Subject: Hydrant condition - BN/139/20/PL The Cottage Highground Lane Barnham PO22 0BT

HYDRANT CONDITION CONSULTATION WITH PLANNING AUTHORITY

Planning Ref: BN/139/20/PL

Address: The Cottage, Highground Lane, Barnham, West Sussex,
PO22 0BT

PROPOSED SITE PLAN & LANDSCAPING

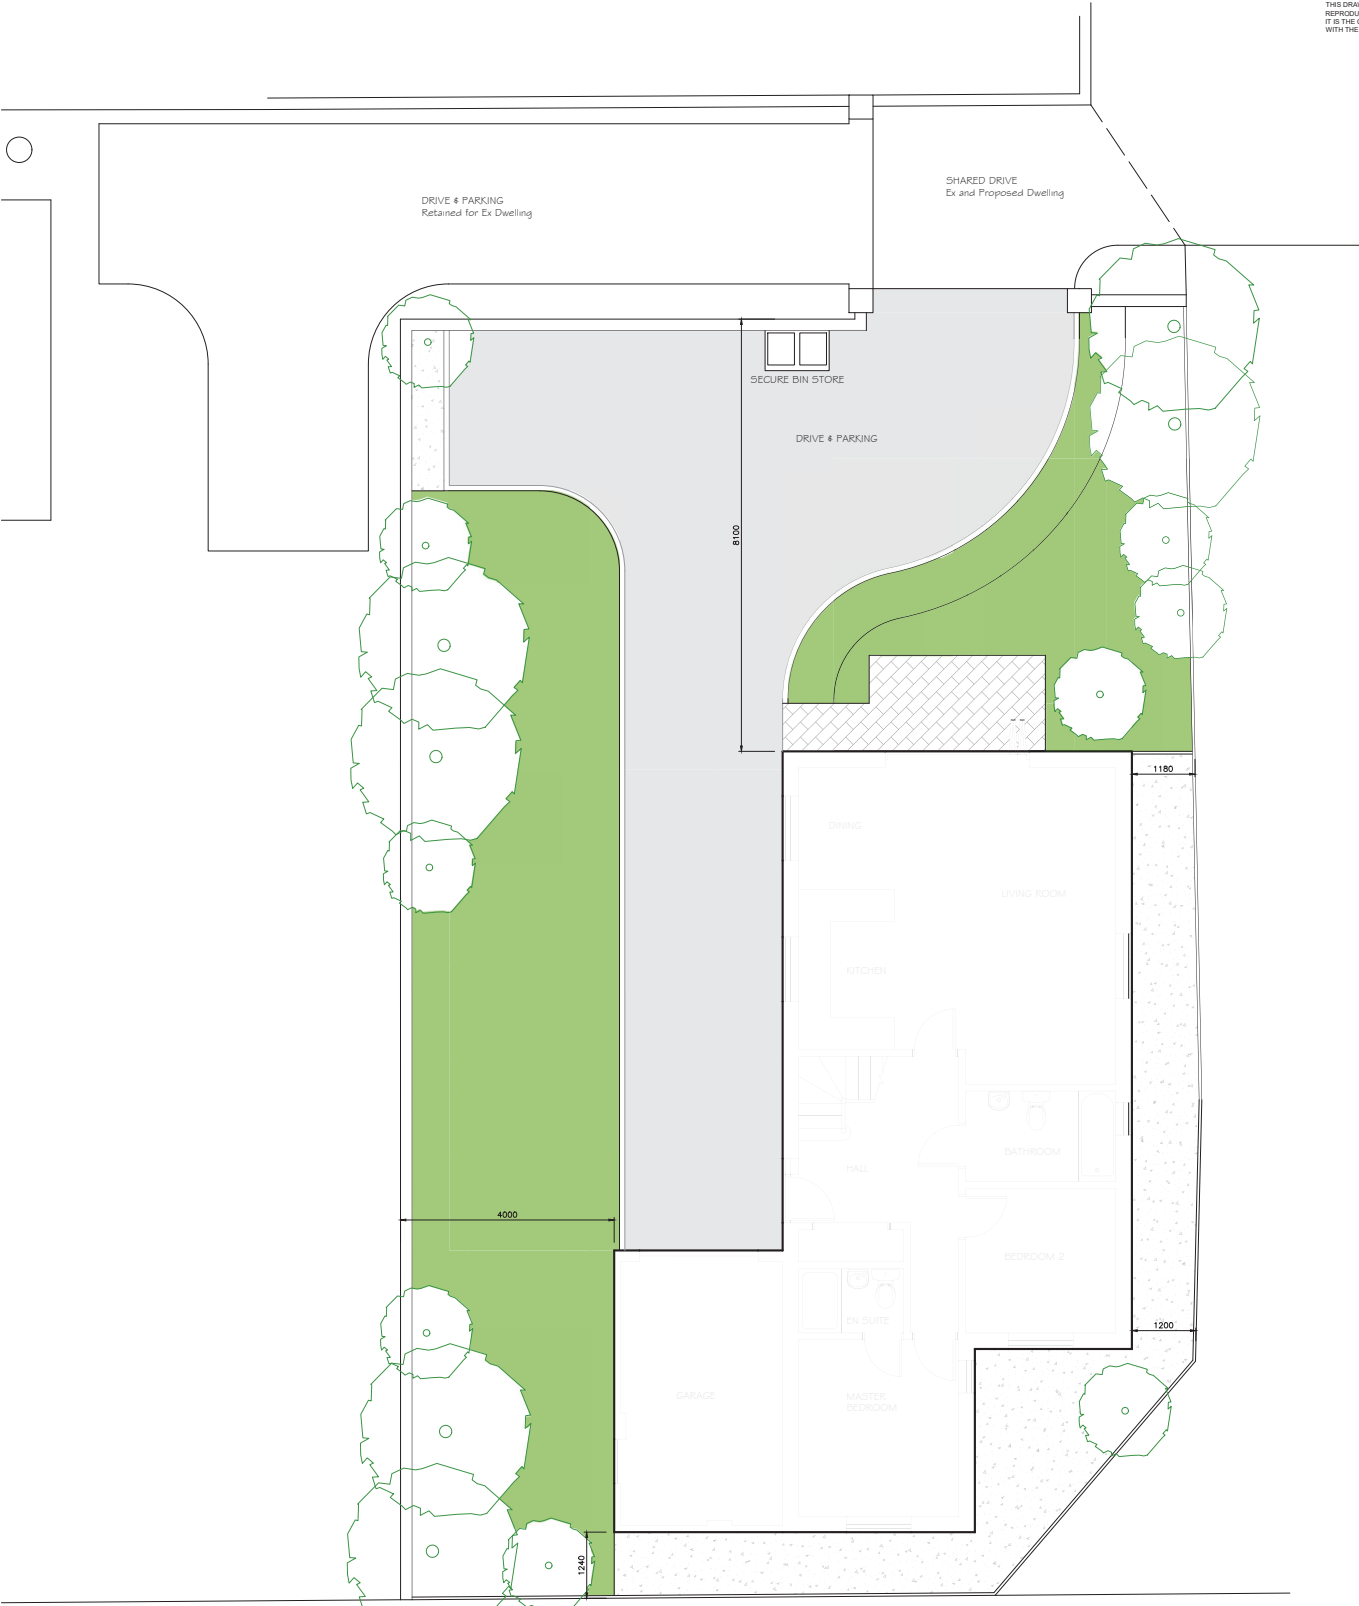
Please find attached a planning condition for application no. BN/139/20/PL for the requirement of an additional fire hydrant. Currently the nearest Hydrant to this proposed properties is 340 metres away. The supply of water for firefighting for a domestic premises should be within 175 metres.

- 1) Prior to the commencement of the development details showing the proposed location of [1] one fire hydrant or stored water supply (in accordance with the West Sussex Fire and Rescue Guidance Notes) shall be submitted to and approved in writing by the Local Planning Authority in consultation with West Sussex County Council's Fire and Rescue Service. These approvals shall not be unreasonably withheld or delayed.
- 2) Prior to the first occupation of any dwelling/unit forming part of the proposed development that they will at their own expense install the fire hydrant (or in a phased programme if a large development) in the approved location to BS 750 standards or stored water supply and arrange for their connection to a water supply which is appropriate in terms of both pressure and volume for the purposes of firefighting.
